RE: Albuquerque School of Excellence – Remodel
13201 Lomas Blvd NE, Albuquerque, NM 87112
(J-22/D050)
Building Permit NO. 201691547

Final Certificate of Occupancy

**RE: Albuquerque School of Excellence
13201 Lomas Blvd NE
Grading and Drainage Plan
Engineers Stamp Date 6/28/16 (J22D050)**

From: Rael, Rudy E.
Sent: Tuesday, June 28, 2016 1:48 PM
To: 'Scott McGee (scottmmcgee@gmail.com)'
Cc: Abiel X. Carrillo
Subject: ABQ School of Excellence

Grading and Drainage Plan

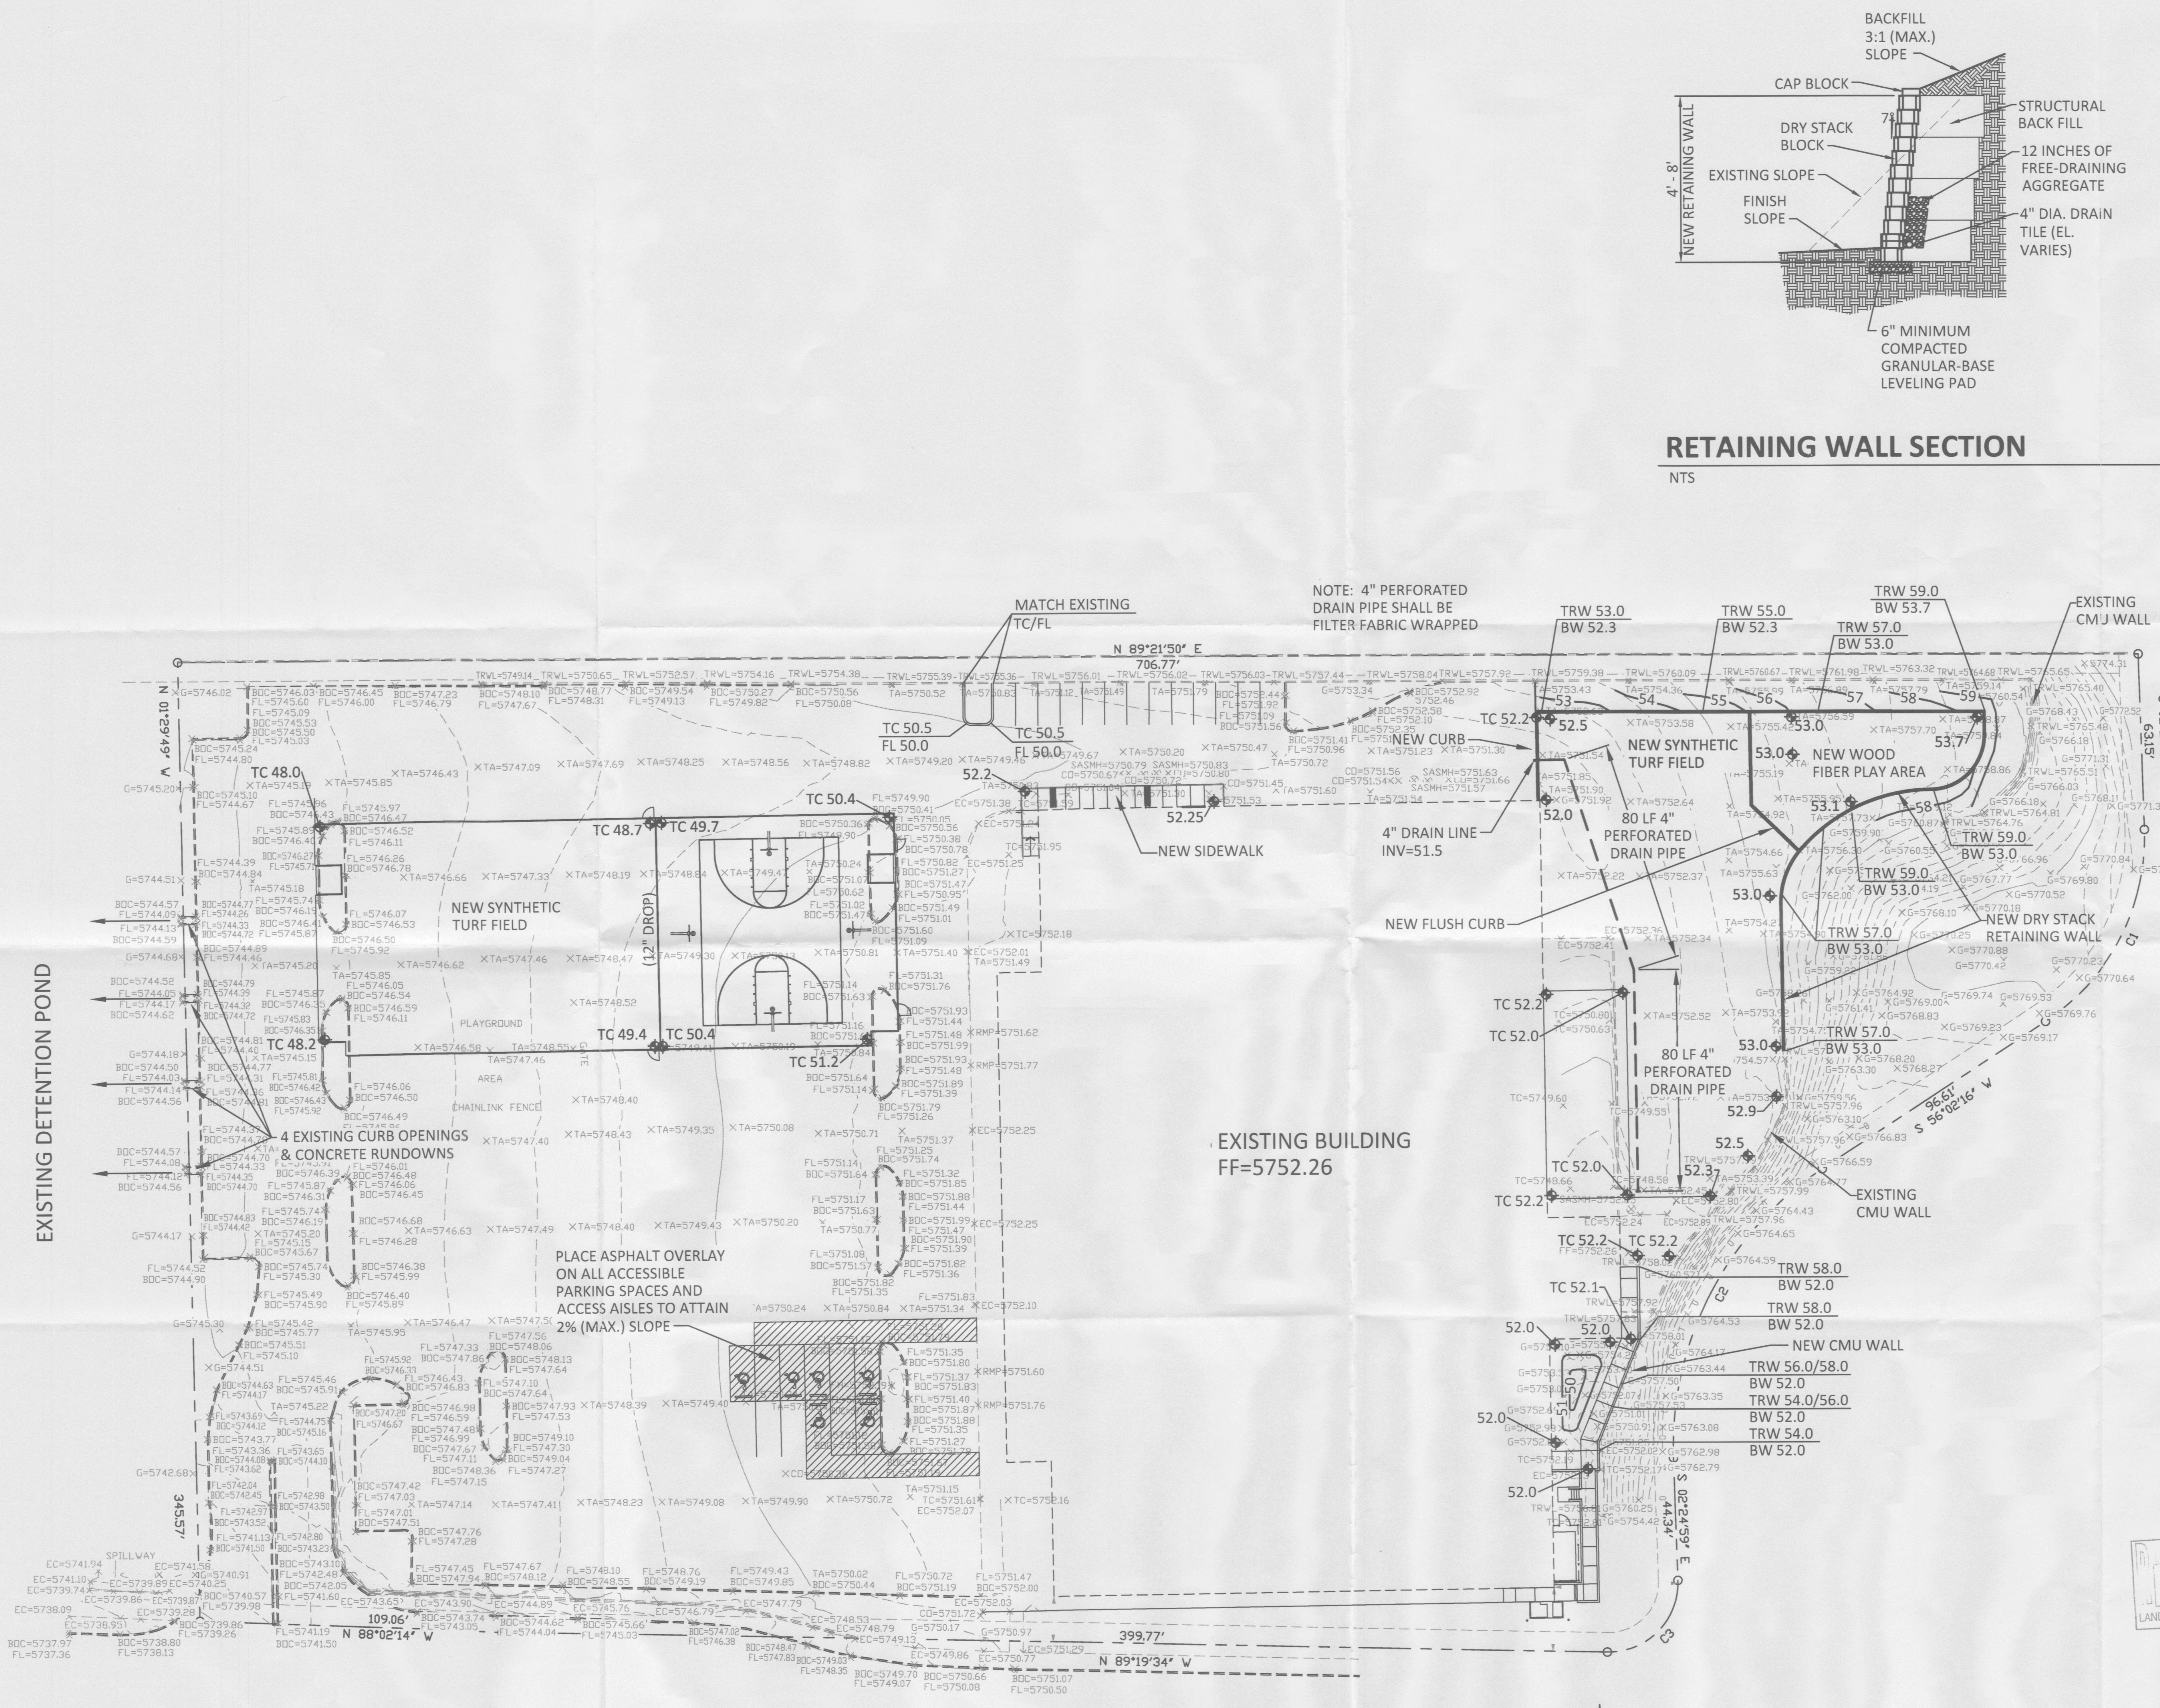
- Provide a detail for the 4" perforated pipe. Show how it will be kept from clogging.
- Show the pond the plan. Provide inlets and outlets.
- If the pond is being used for the First Flush, it must be cleaned, free of weeds and what not.
- Is it possible to provide curb openings in the landscape Islands for first flush ponding?
- Label the double line on the east side of the building. What is it, wall, curb, etc.?

TRAFFIC CIRCULATION LAYOUT PLAN

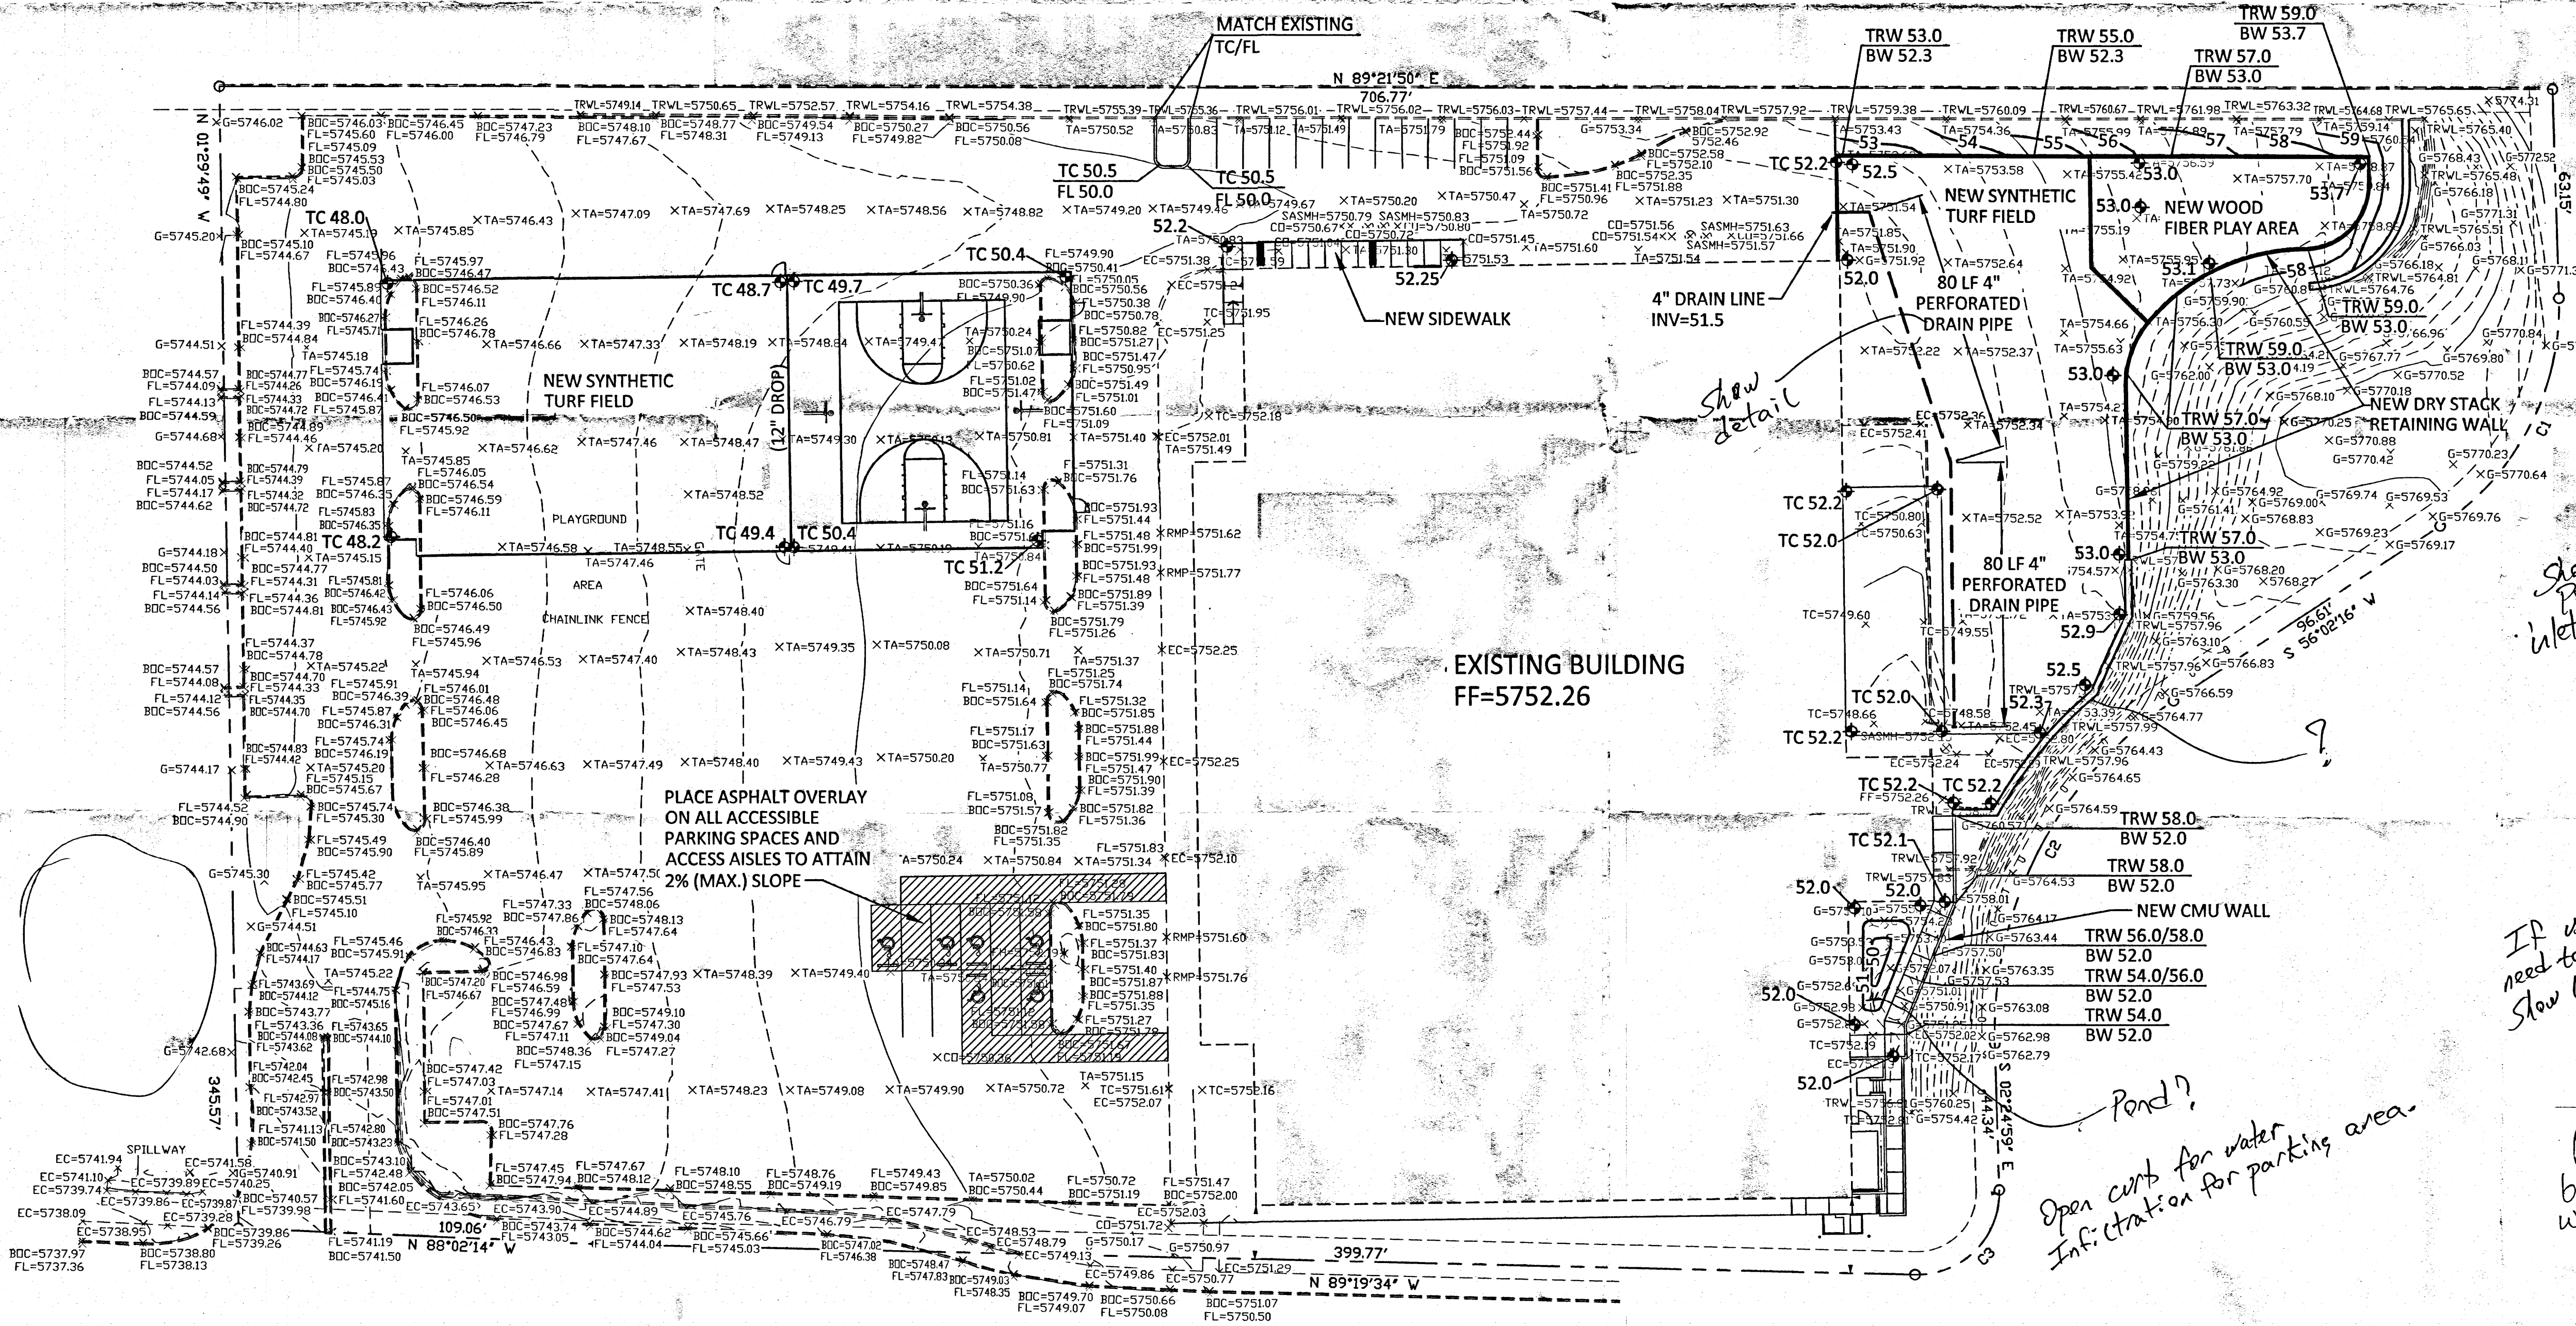
1. Please identify all existing buildings, doors, sidewalks, ADA ramps, curbs, drive pads, wall and anything that influences the parking and circulation on the site.

2. Please call out ADA ramps and truncated domes on drive pad crossings, which are required at all public ROW crossings.
3. Identify all existing access easements and rights of way width dimensions.

4. Identify the right of way width, medians, curb cuts, and street widths on Lomas Blvd. and Tramway Service Rd. Please detail the drive pad width north of the entrance off of Lomas Blvd.,

5. The handicap accessible spaces must be a minimum of 8.5 ft. in width.
6. The handicap accessible spaces must include an 8 ft. wide van access aisle; all other aisles should be 5 ft. in width.

7. The ADA accessible parking sign must have the required language per 66-7-352.4C NMSA 1978 **"Violators Are Subject to a Fine and/or Towing."** Please call out detail and location of HC signs.

8. The ADA access aisles shall have the words **"NO PARKING"** in capital letters, each of which shall be at least one foot high and at least two inches wide, placed at the rear of the parking space so as to be close to where an adjacent vehicle's rear tire would be placed. (66-1-4.1.B NMSA 1978)

9. Per DPM, a 6 ft. wide ADA accessible pedestrian pathway is required from the public sidewalk to the building entrances. Please clearly show this pathway and provide details. In review of the submitted drawing, the proposed ADA access from the ROW is 5 ft. in width.

10. Per DPM, a 6 ft. wide ADA accessible pedestrian pathway is required from the HC parking stall access aisles to the building entrances. Please clearly show this pathway and provide details. It not permissible to have the ADA access isle from the HC parking guide pedestrians behind parking spaces in order to enter building.

11. Provide a min 6" or max 8" high concrete barrier curb or other acceptable barrier between landscaping and parking areas and/or drive aisles. Please call out detail and location of barrier curb.

12. Service vehicle and/or refuse vehicle maneuvering must be contained on-site; provide a copy of refuse approval.
13. One-way vehicular paths require pavement directional signage and a posted "Do Not Enter" sign at the point of egress. Please show detail and location of

14. Please provide a sight distance exhibit (see the *Development Process Manual, Chapter 23, Section 3*). Please show this detail for the entrance/exit on Lomas Blvd.

15. Please add the following note to the clear sight triangle: "Landscaping and signage will not interfere with clear sight requirements. Therefore, signs, walls, trees, and shrubbery between 3 and 8 feet tall (as measured from the gutter pan) will not be acceptable in this area."

16. Please add a note on the plan stating "All improvements located in the Right of Way must be included on the work order."
17. All broken or cracked sidewalk must be replaced with sidewalk and curb & gutter. A build note must be provided referring to the appropriate City Standard drawing.
